STATE OF NORTH CAROLINA
DEPARTMENT OF TRANSPORTATION

October 18, 2022

Subject: Request for Modification to Section 404 Individual Permit and Section 401 Water Quality Certification for the I-26 Widening from NC 225 (US 25 Connector) in Henderson County to I-40 in Buncombe County, Federal Aid Nos. NHF-26-1(62)23 / I(MNHF-026-1(86)9, TIP Project Nos. I-4400/ I-4700; Divisions 14 / 13. Debit \$570 from WBS No. 34232.1.6

**PERMIT DRAWING
SHEET 59 OF 97**

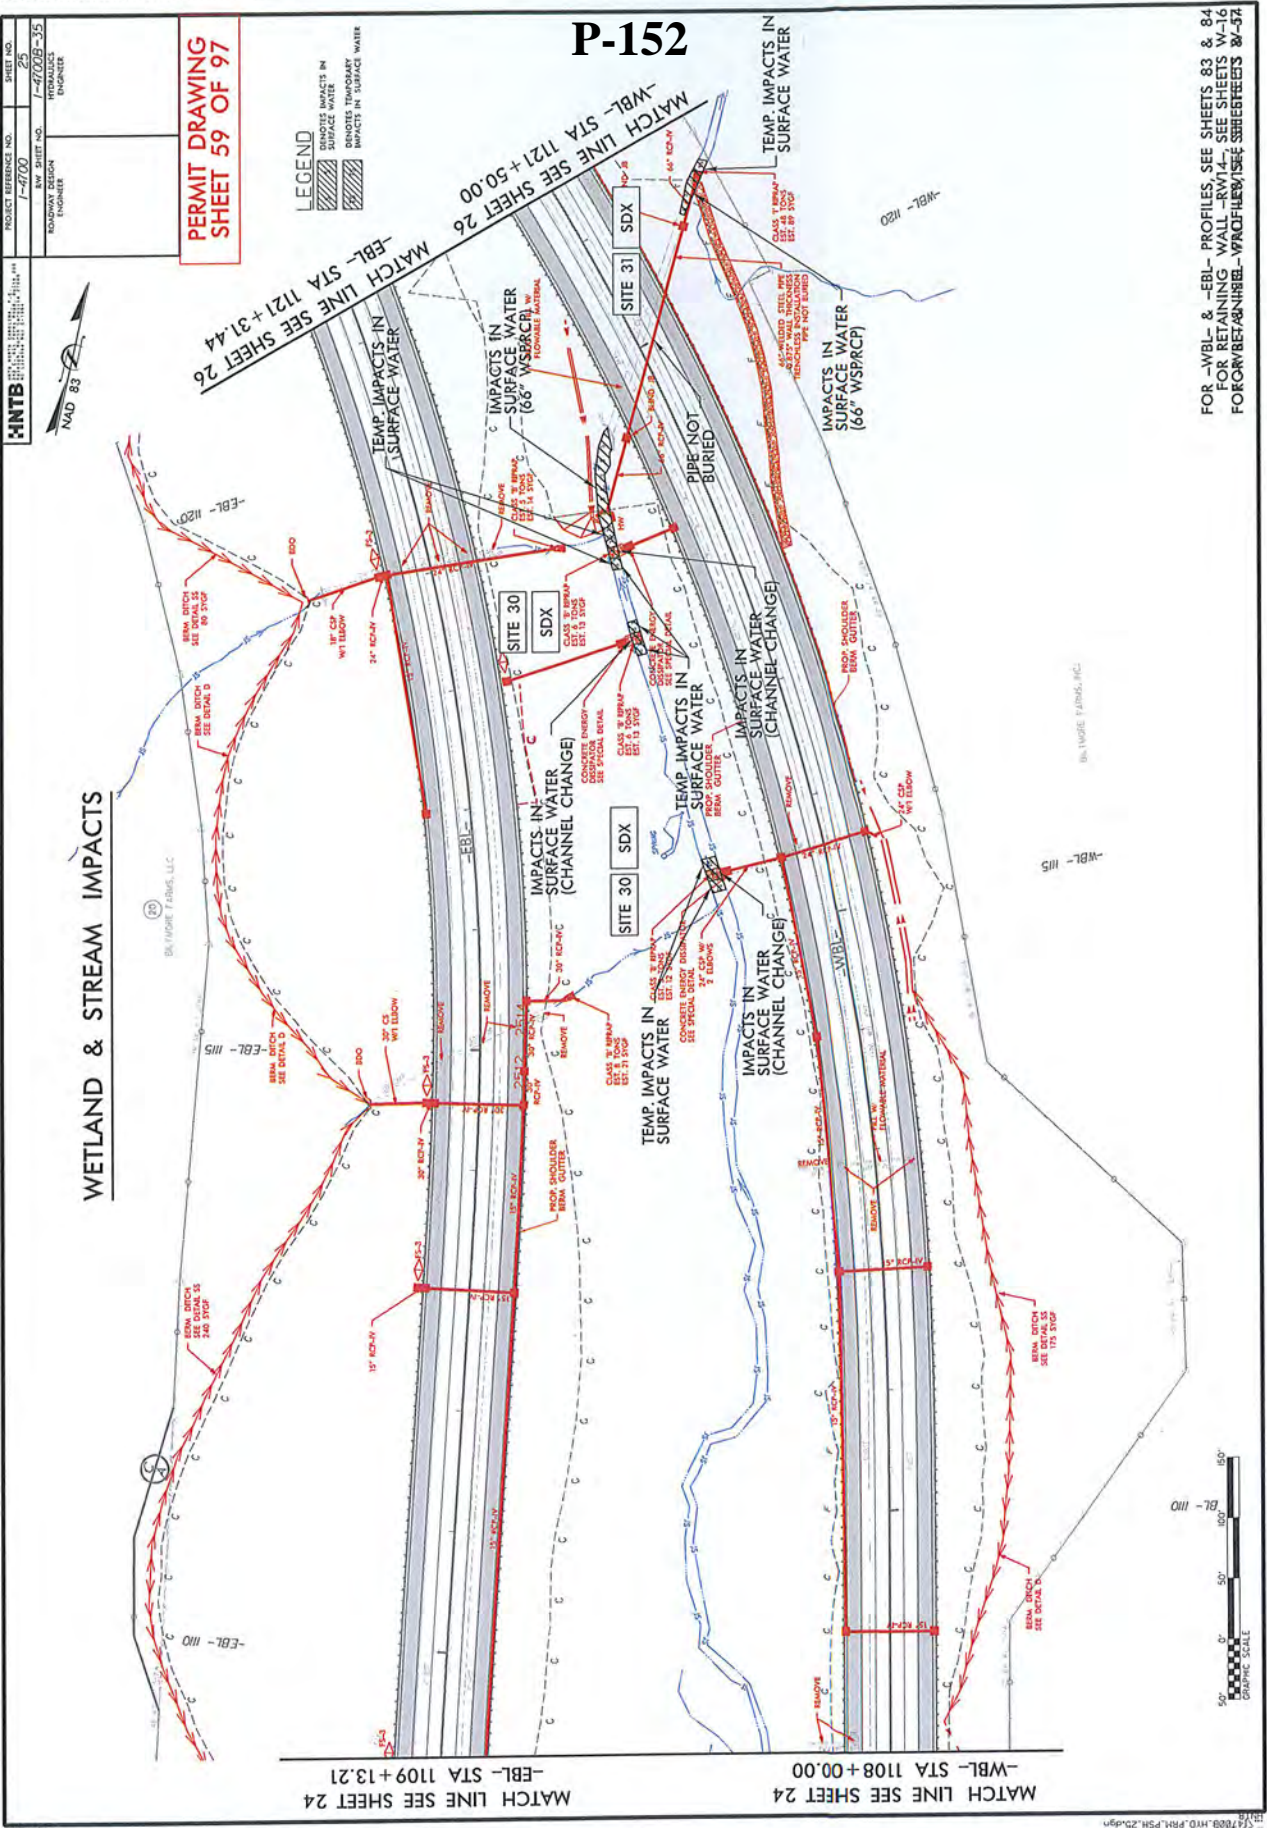
Site 30 (Permit Drawing Sheet 59) – This site has been updated to replace the existing 66” RCP with a 9’x7’ RCBC. This will include riprap bank stabilization along stream SDX. Changing the pipe to a box culvert will reduce temporary impacts upstream at the outlet of the proposed 15” Corrugated Steel Pipe (CSP). The replacement of the 66” RCP with the 9’x7’ RCBC will result in an increase in permanent impacts to the stream from 70’ to 78’. A net total increase of 8’. Riprap is proposed at the inlet of the RCBC for bank stabilization. The additional bank stabilization is a new permanent impact of 25 feet.

Site 31 (Permit Drawing Sheet 59) – This site has been updated to reflect the proposed replacement of the existing 66” RCP with the 9’x7’ RCBC. The new RCBC will result in 8 feet of permanent stream impacts compared with the original 38 feet, and zero (0) temporary impacts, reduced from 10 feet. This results in a decrease of 30 feet in permanent impacts and 10 feet in temporary impacts. However, the new channel change (with embedded riprap) as a result of the proposed RCBC will result in 20 feet of new permanent impacts and 10 feet of new temporary impacts.
